SUBSURFACE WASTEWATER DISPOSAL SYSTEM APPLICATION

PROPERTY LOCATION  
City, Town, or Plantation: Cliff Island (Portland)  
Street or Road: 226 Sunset Road

SUBJECT: Seasonal Replacement System Variance Request, Lux property, 226 Sunset Road, Cliff Island, Portland, Maine.

**SUBSURFACE WASTEWATER DISPOSAL PLAN**

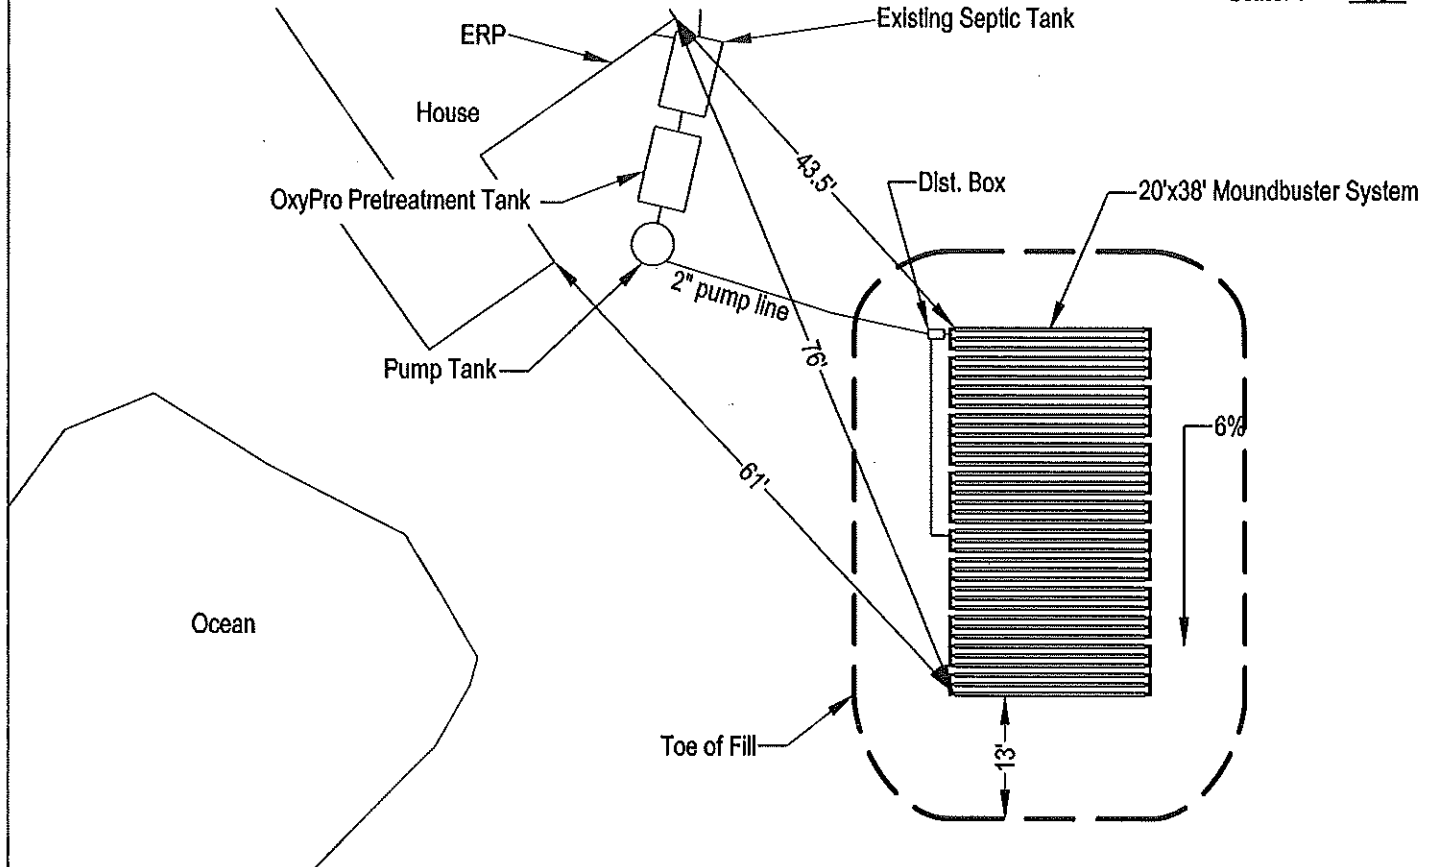
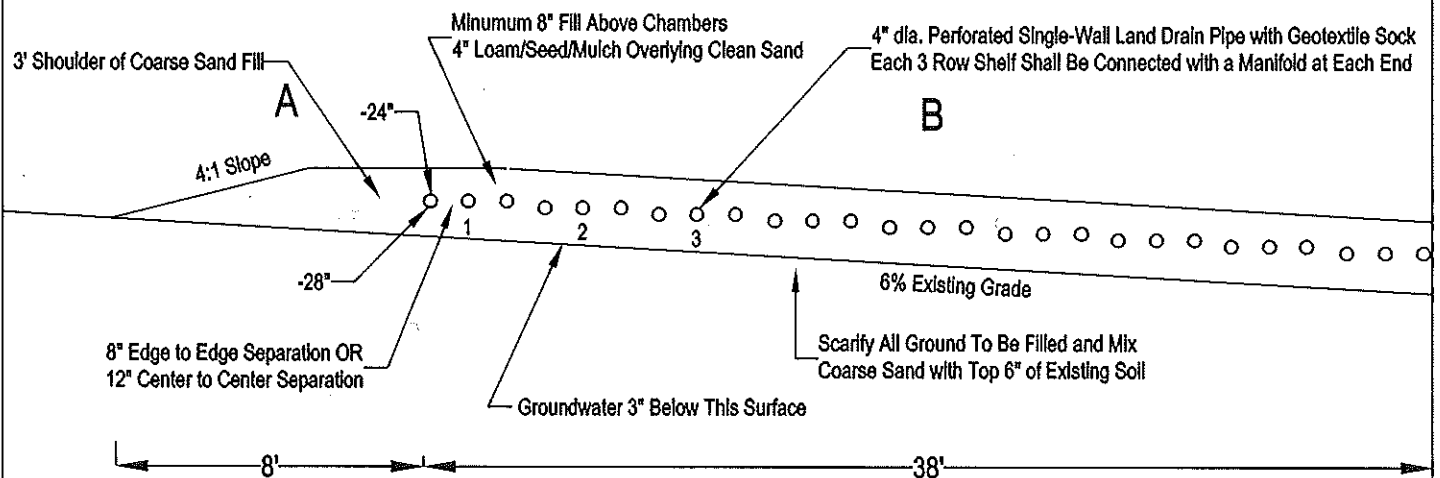
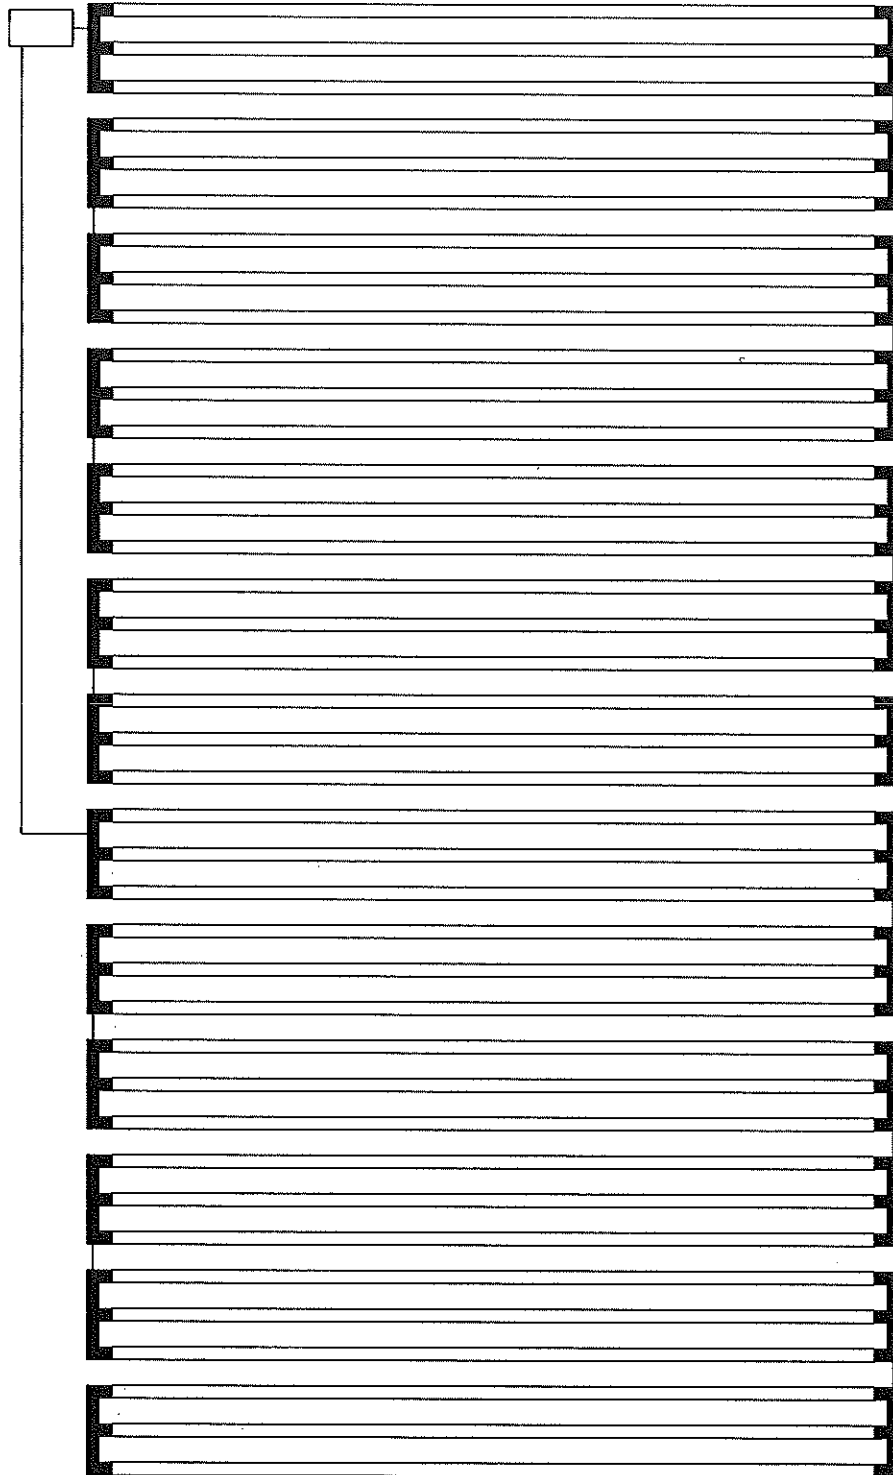
The variance requested which is not within the LPI's authority is from the soils to the groundwater table of 3 inches, also from the disposal field to a major water course of 50 feet..

The variances requested that is within the LPI's authority is from the disposal field to the owners well of 95 feet and from the soils to the restrictive layer of 9 inches.

As we understand the situation, the variance request has been submitted because topography and existing development limit the potential of the system location and the system design prepared by Richard Sweet, SE #34 on 09-17-08 is otherwise found to be in compliance with the Maine Subsurface Wastewater Disposal Rules.

1. A permit for system installation is to be obtained from the Local Plumbing Inspector in advance of the start of system construction.
2. The system is to be installed in accordance with the submitted and approved system design. Should alterations to the design be required at the time of construction, the site evaluator is to be notified prior to making any changes.
3. The contractor is to scarify the soils under the fill extensions to create a transitional zone more compatible with the disposal field area.
